Appeal Decision

Appeal Ref: APP/R5510/D/24/3351687

3 Belmont Close Uxbridge UB8 1RF

- The appeal is made under section 78 of the Town and Country Planning Act 1990 (as amended) against a refusal to grant planning permission.
- The appeal is made by Mr Harpaviter Singh Dhami against the decision of the Council of the London Borough of Hillingdon.
- The application Ref is 76133/APP/2024/1185.
- The development proposed is erection of a first floor side extension.

PROPOSED FRONT
ELEVATION

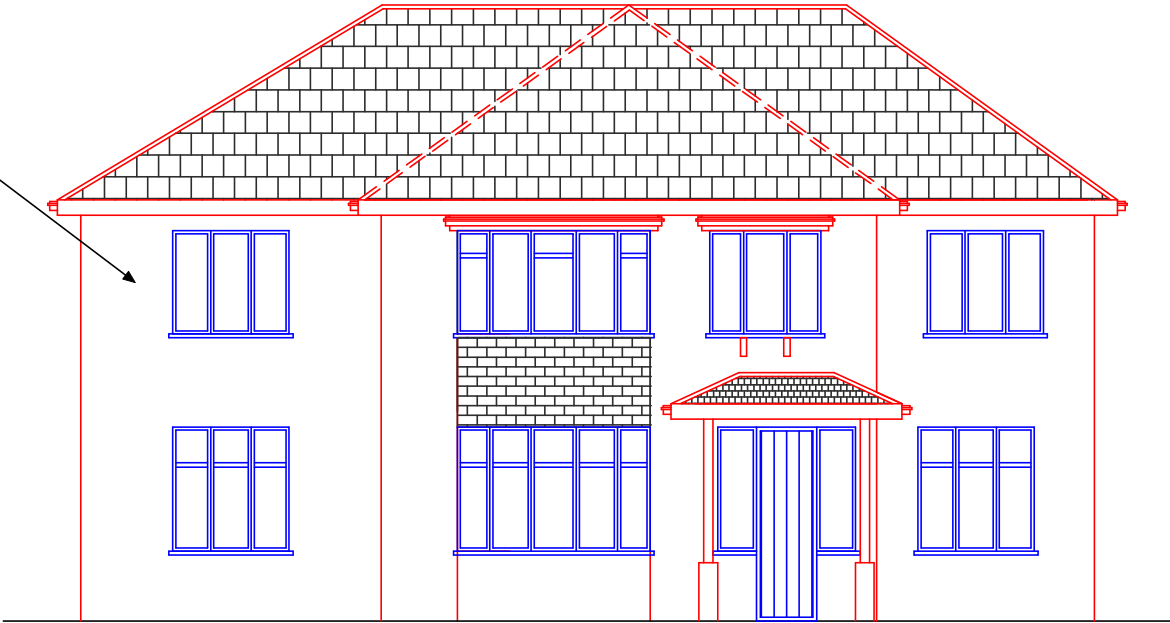
5. The proposal seeks to add an upper storey to a recently-constructed single storey flat-roofed side extension that currently is apparent but not unduly prominent in the

street scene. This recent extension, together with a two storey side extension¹ on the opposite (north) side of the original house has already introduced a significant change in the way this house relates to the street such that it no longer sits *within* its plot, with an associated spaciousness around the houses as was typical of locality originally did, but fills its width. The effect of such change is, cumulatively, to fundamentally change the largely open character of the original development pattern north side extension has introduced a side wing of roof with a similar height of ridge and an unnecessarily continuous eaves line which, taken together, undermines the significance of the original pyramid² roof whilst falling short of the introduction of an overbearing near-symmetry in the principal elevation to the street scene which would be the result of what is now proposed.

PROPOSED ROOF PLAN

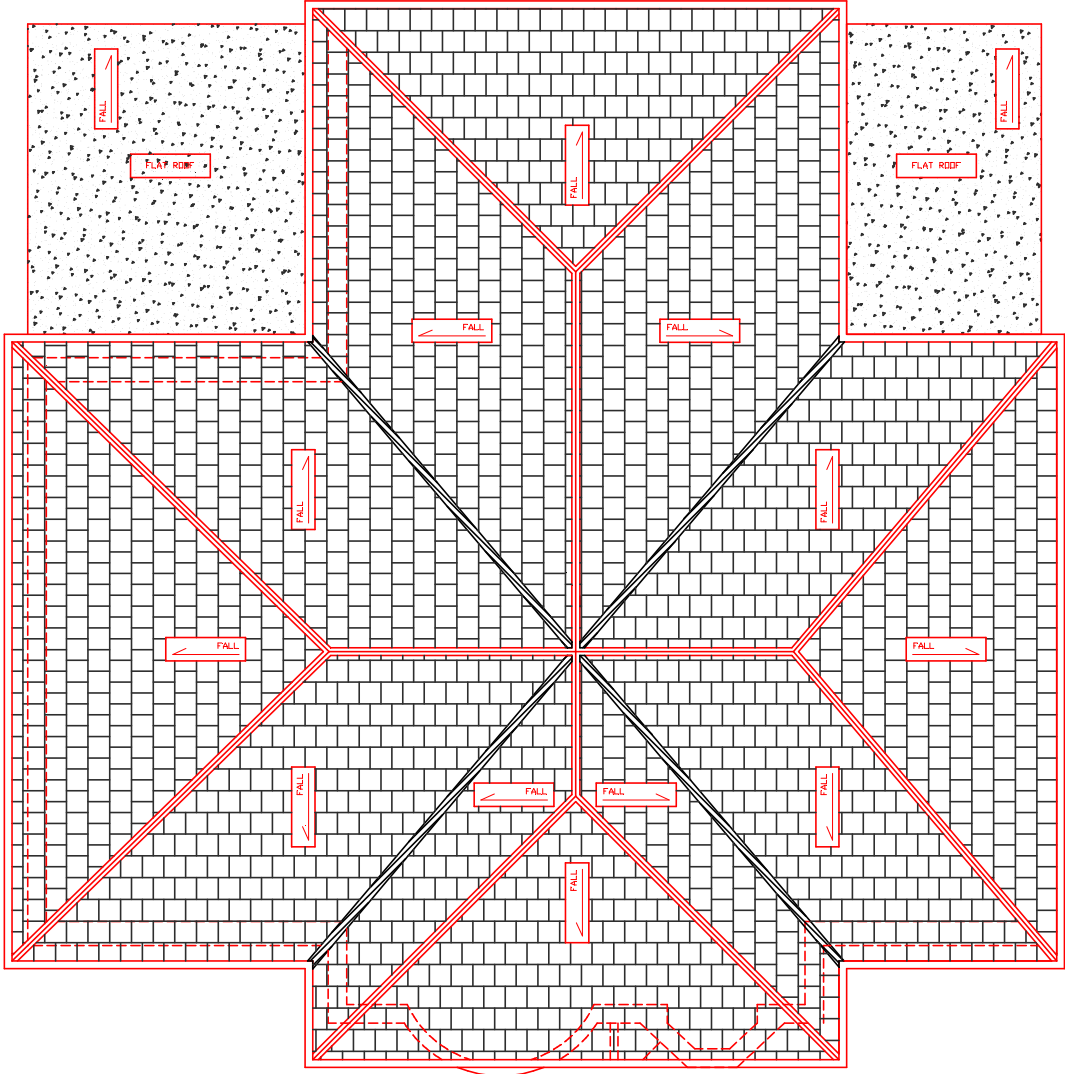
6. The proposal indicates that the upper-storey extension would be hip-roofed to suit the main ridge height but, due to its depth, would be inconsistently pitched, a factor of the design which, although not likely to be readily apparent in the street scene, nevertheless fails to respect the architectural principles evident in the original arts and crafts-derived designs which, in most examples, expressly avoided classical design principles such as symmetry.
